Your Ref: OWPC16904
Our Ref: FP/302/17/PL 04-12-2017
Please ask for:
Mr S Davis

Outbuilding
10 Kingsmead Felpham

NOV 2017
1-100, 1-500
DRG 1A

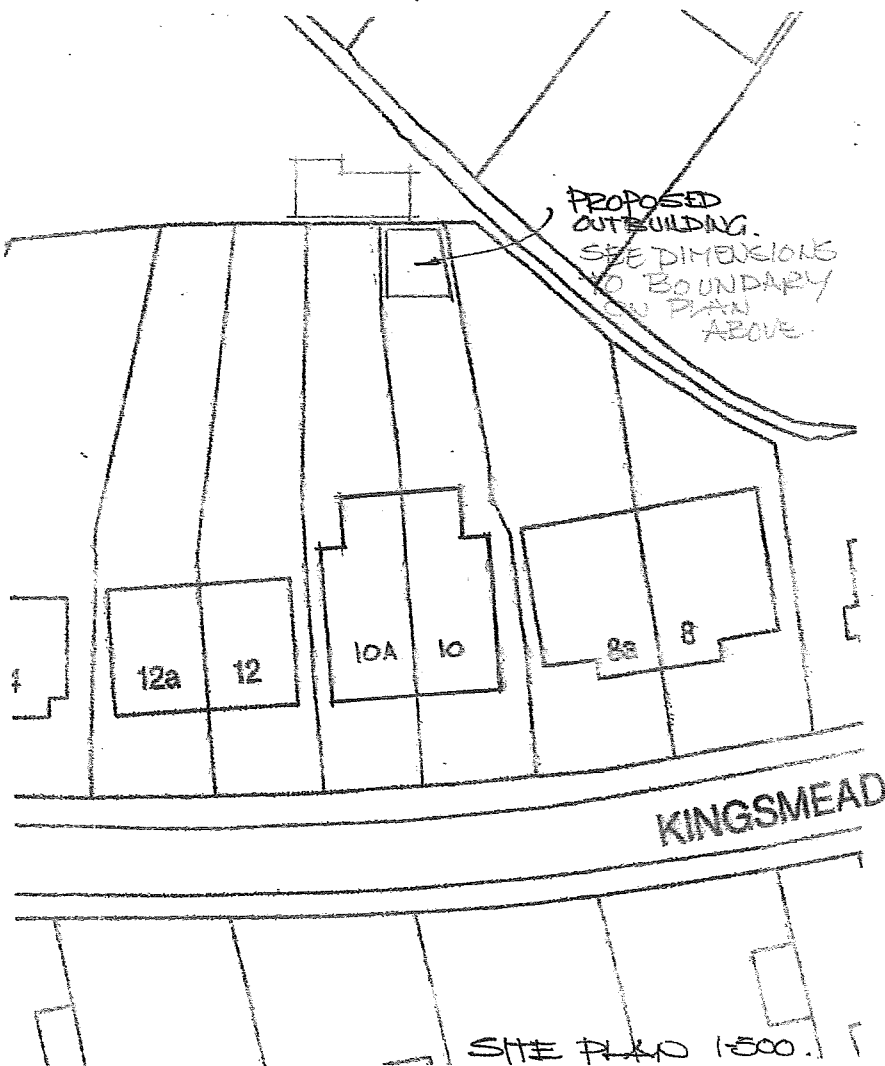
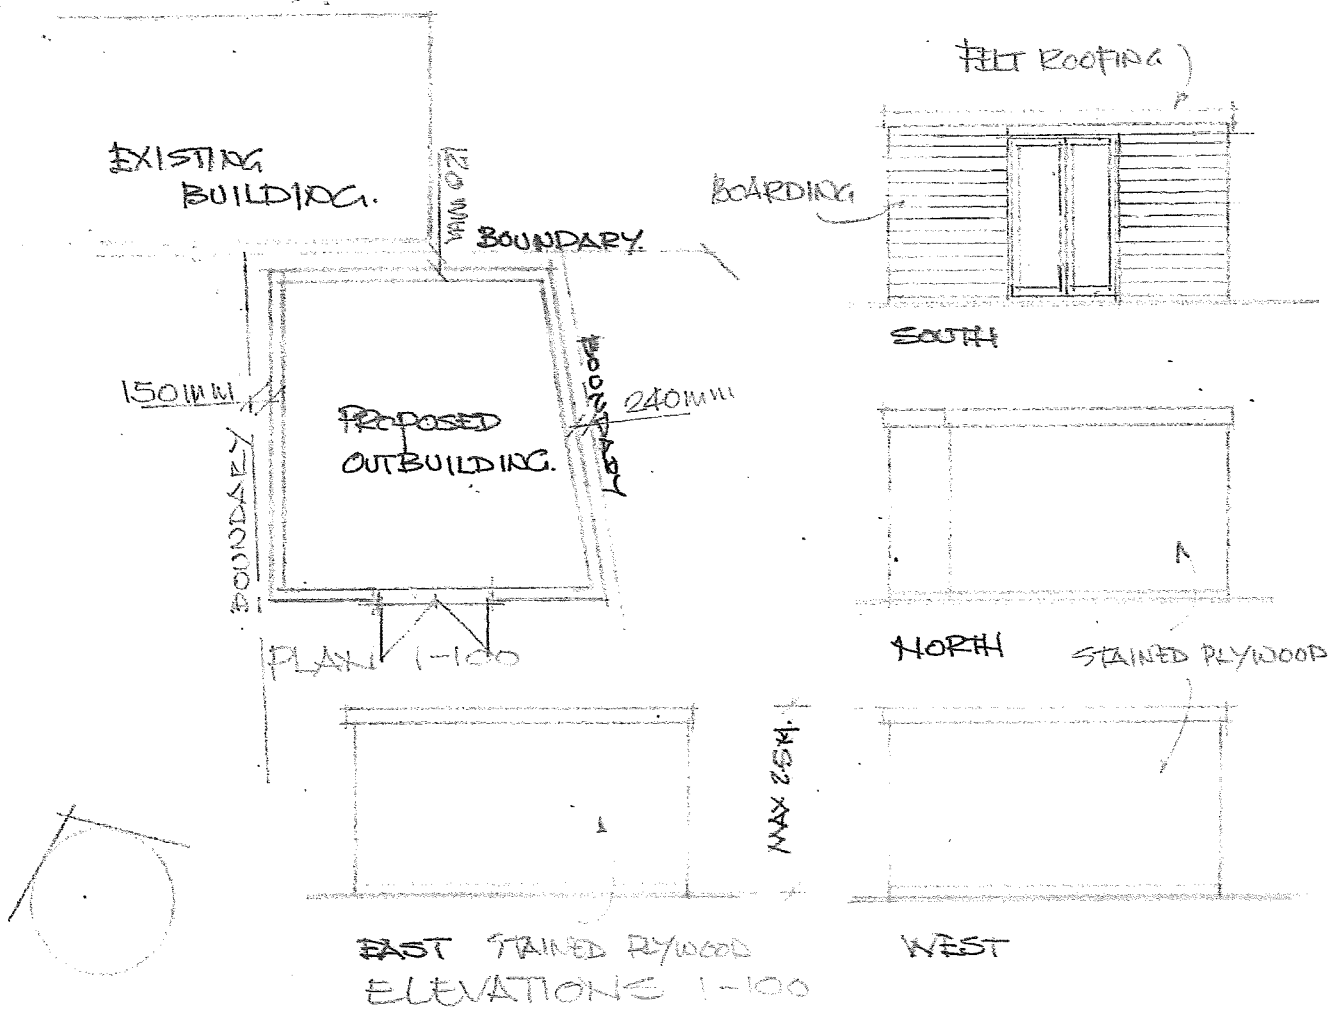
Object due to proximity to our boundary and the height and size of the outbuilding it will overlook our back garden and interfere with our privacy
